# Comment for planning application 22/00747/OUT

2 Foul Water Indicative Strategy

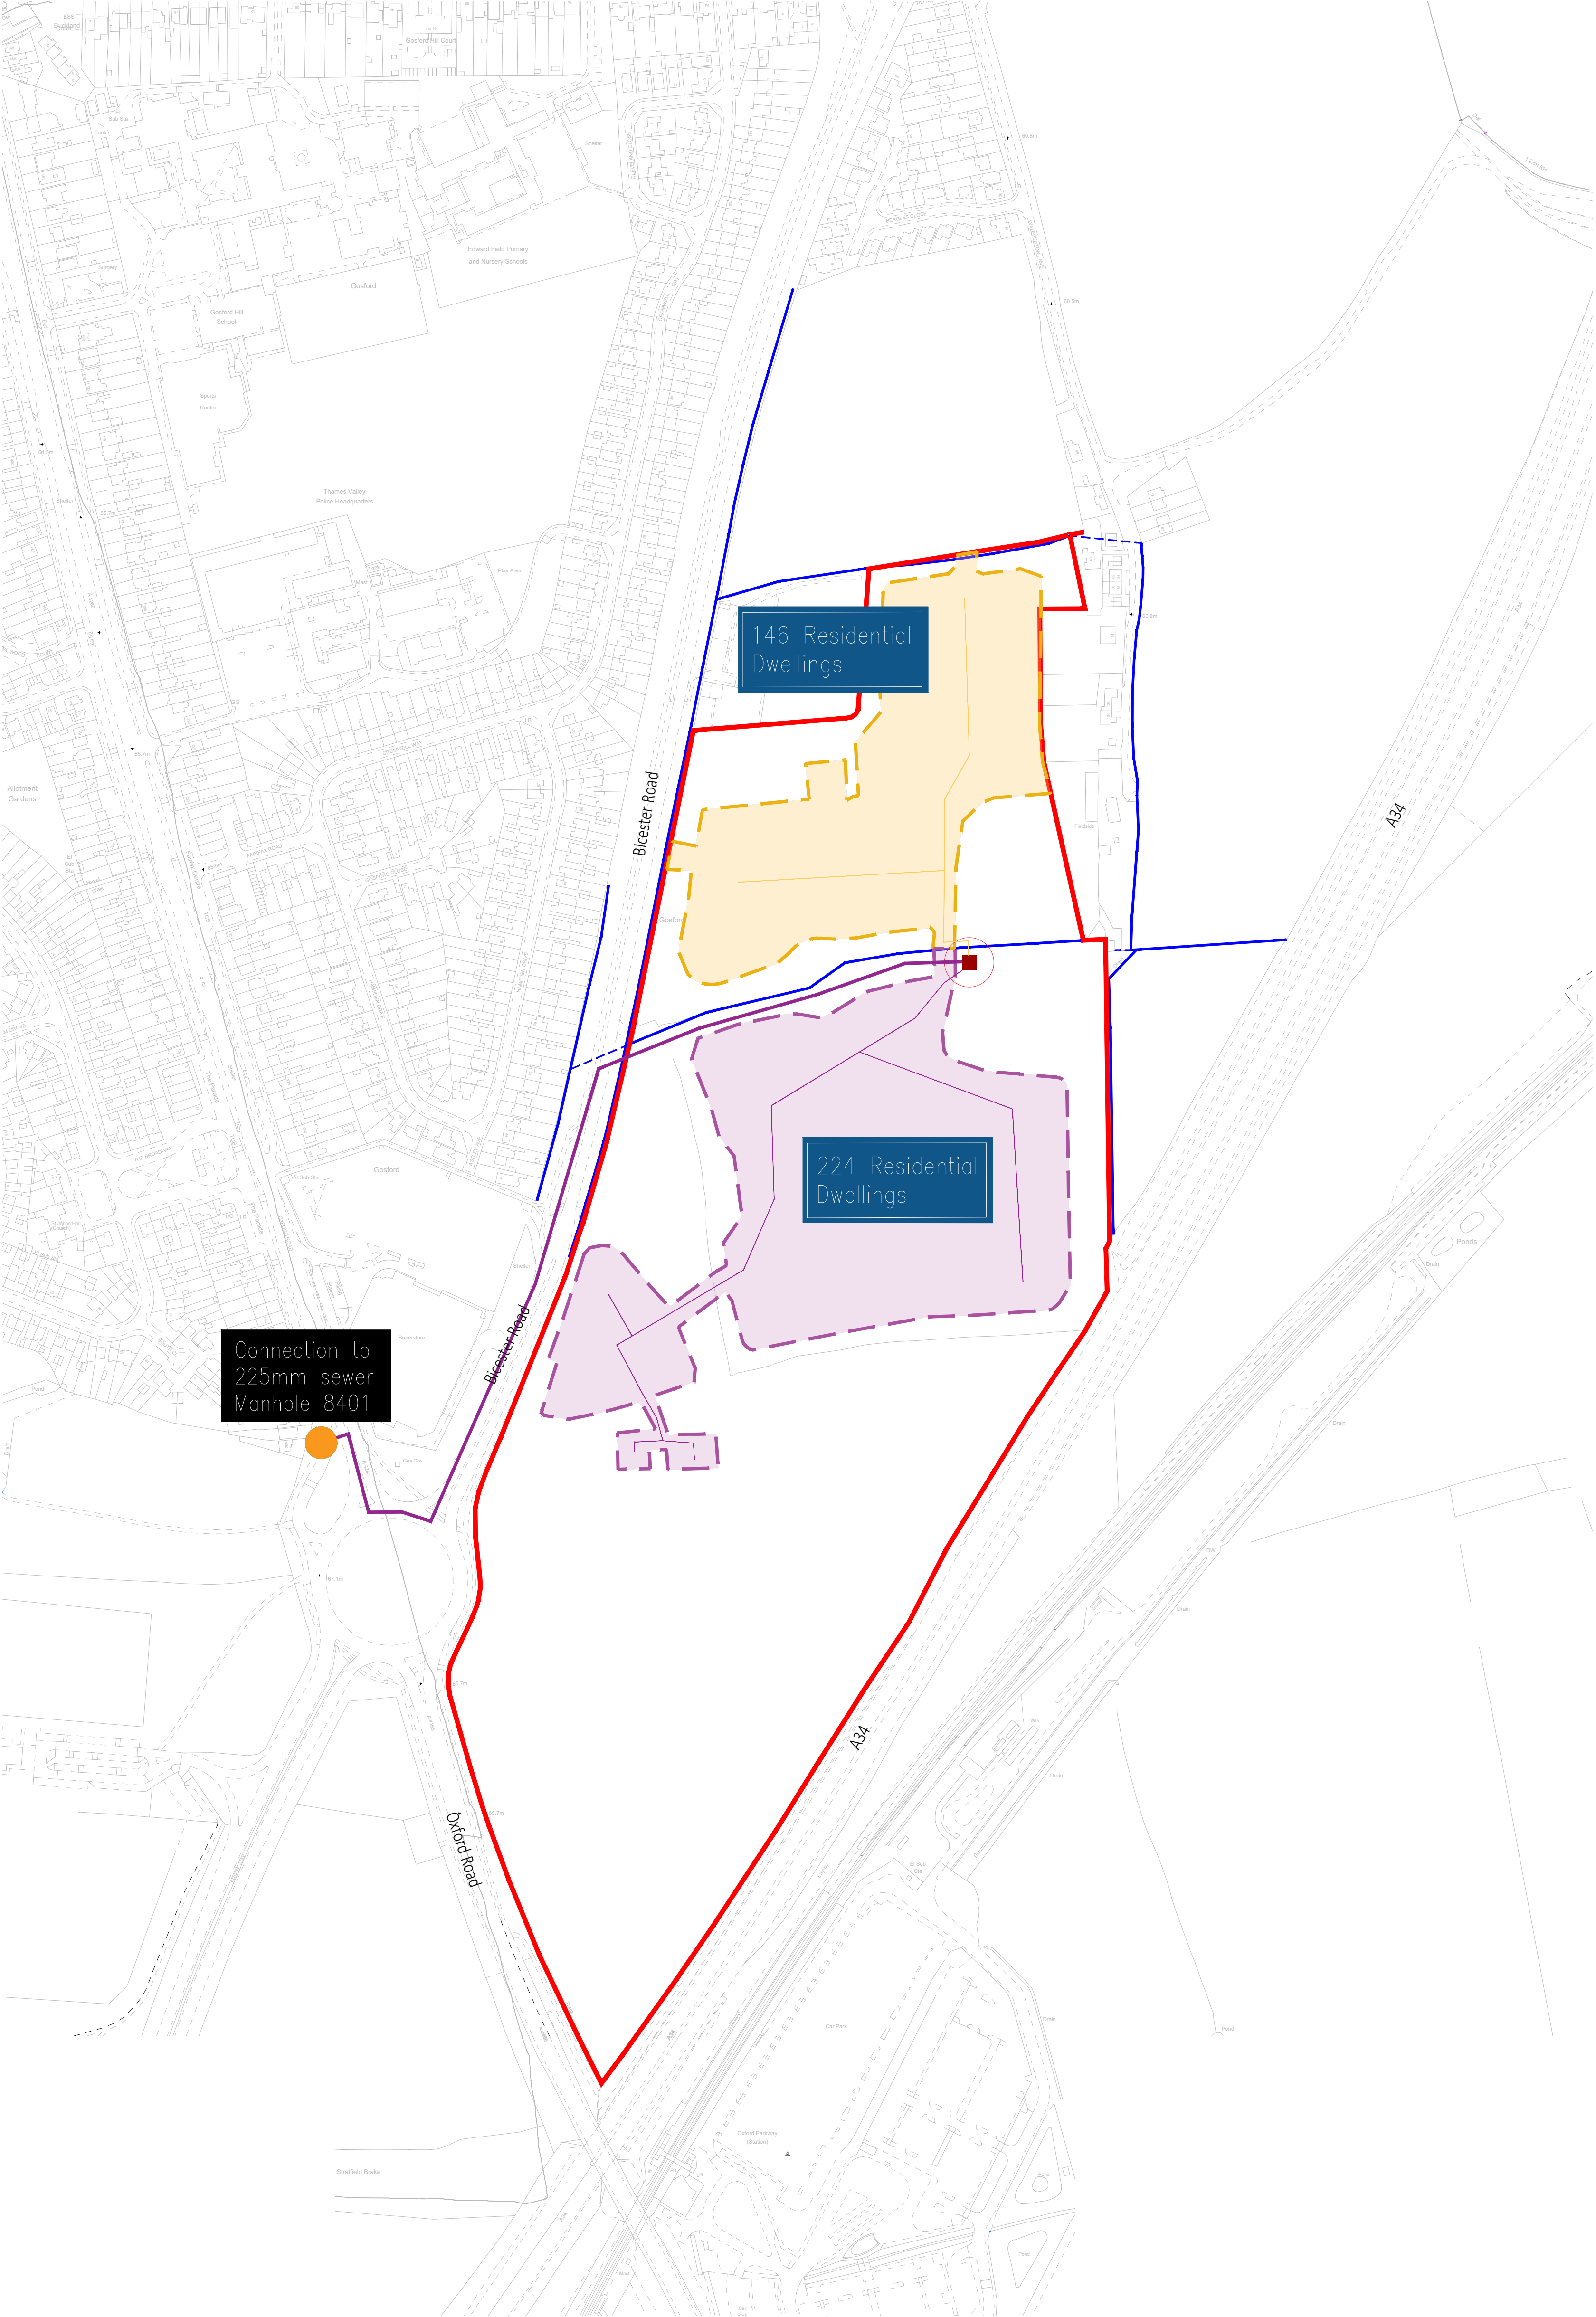
pedestrians and cyclists can have a seamless journey between this site and Stratfield Brake without travelling along the main Bicester Road or Oxford Road except for the crossing of the roundabout. Foul Drainage and Water supply infrastructure Kidlington Parish Council objects as there are no details of how the foul drainage will be handled however there is a passing reference to a pumping station and an indication that there will not be a need for offsite works. The comments from Thames Water regarding foul drainage and water supply are concerning. They indicate that they have not been able to contact the applicant to discuss the necessary infrastructure required. We consider that this matter is fundamental to the delivery of the development and needs to be resolved before consent is granted. Viability The Local Plan allocation for site PR7a includes a substantial list of S106 requirements to enable the development of this site. The application has given no clear commitment to delivering all the requirements. Without the commitment of the developer to deliver the range of facilities and off-site contribution considered by Cherwell District Council to deliver this development Kidlington Parish Council considers the development as currently proposed unacceptable. Allotments The Partial Review of the Local Plan specified that allotments should be provided within the developable area, as did the draft development brief for the site. The developer now proposes to put them within the Green Belt triangle South of the developable area. The Parish Council strongly objects to this. The Green Belt triangle has significant iconic value as the last remaining piece of the Kidlington gap north of the Oxford Road. The mix of playing fields and parkland that the Local Plan proposes for the site is thus an essential amenity. The effect of putting the allotments in this triangle will be to reduce the parkland area and the attractions of the triangle, especially if the allotments are to be fenced off. Conclusion Whilst this application is in outline with means of access the only reserved matter included it gives a general future direction for the form of development likely to be covered in future reserved matters applications. As such Kidlington Parish Council considers the application premature with issues referred to above needing to be resolved satisfactorily before development on this part of site PR7a can be satisfactorily taken forward.
